**App no: 24.0998**

**Address: The Compleat Food Group Lincoln Way Clitheroe BB7 1QL**

**Proposal: Proposed alterations to car parking, access and installation of new exit gates.**

Site Location Plan

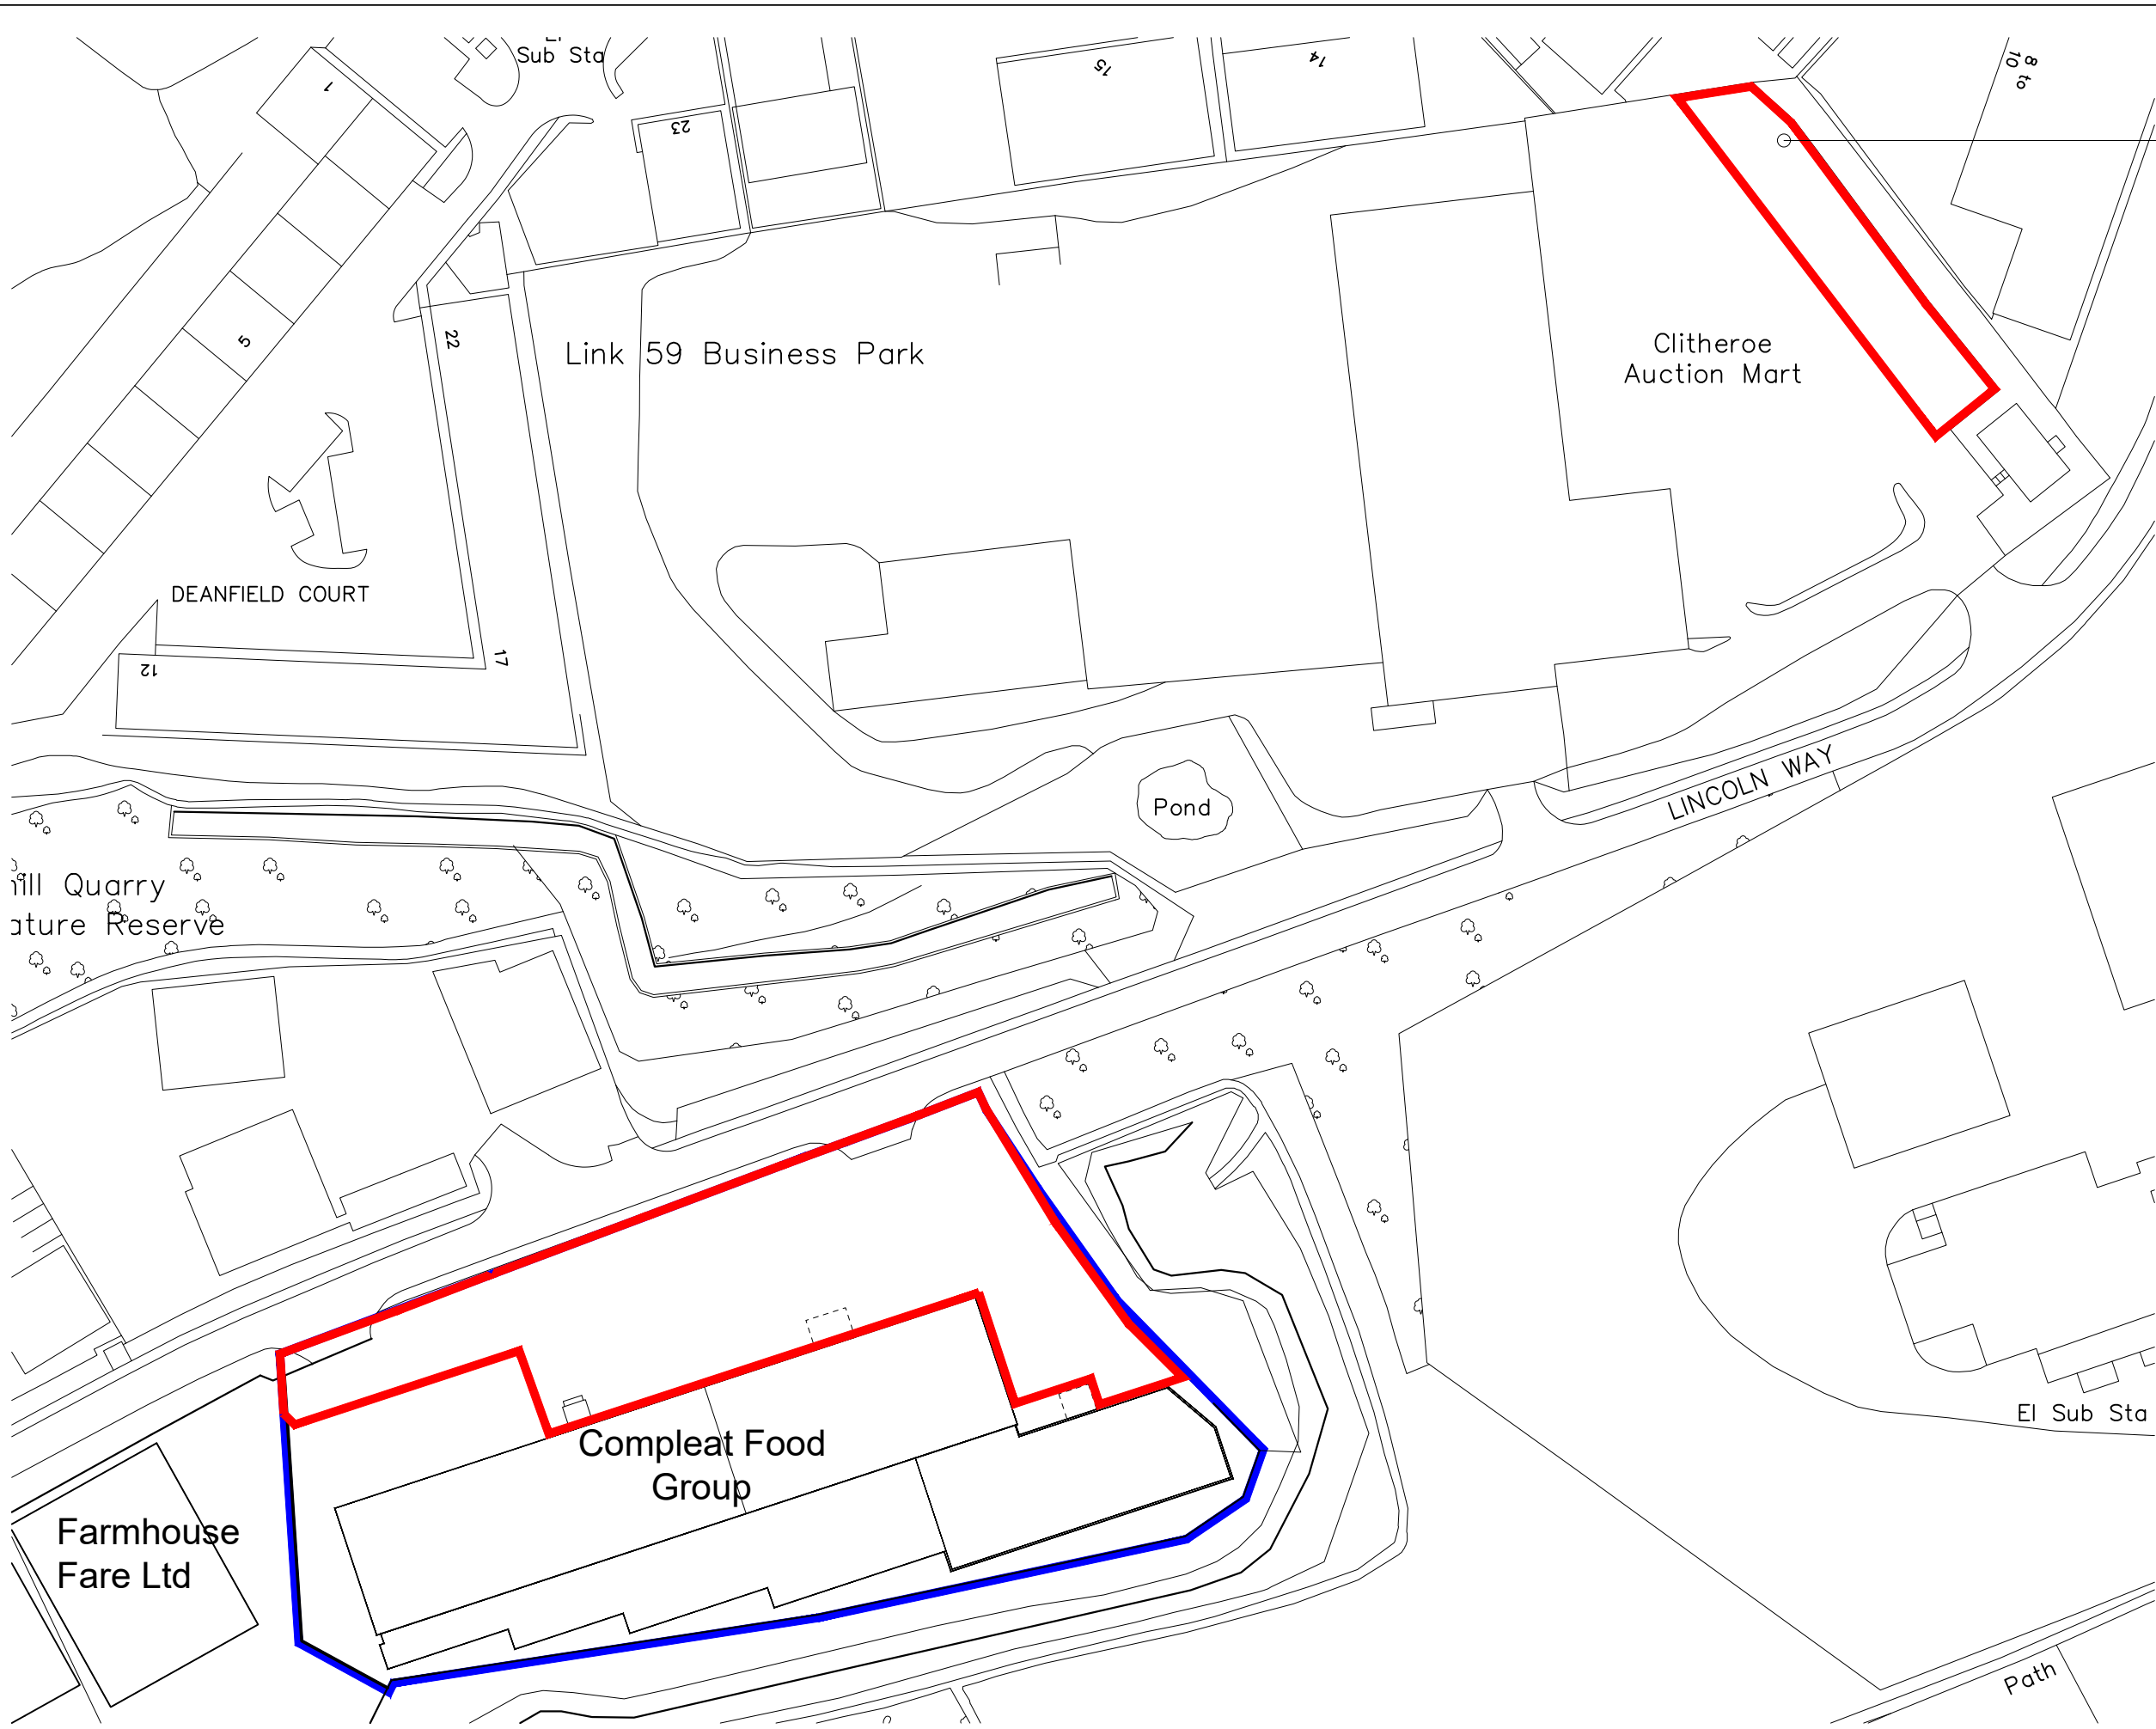
A drawing is submitted to show the location of the car parking within the Auction site. The area of hard standing is unmarked. The long side provides around 28 spaces and it could be assumed that some staff on the same shift could double park to increase the capacity to sufficient levels.

There are no details submitted regarding the times when staff are on-site and that it does not conflict with any users at the Auction. We would request that if the agreement with the Auction is terminated at any point in the future, that a replacement car parking provision is provided.
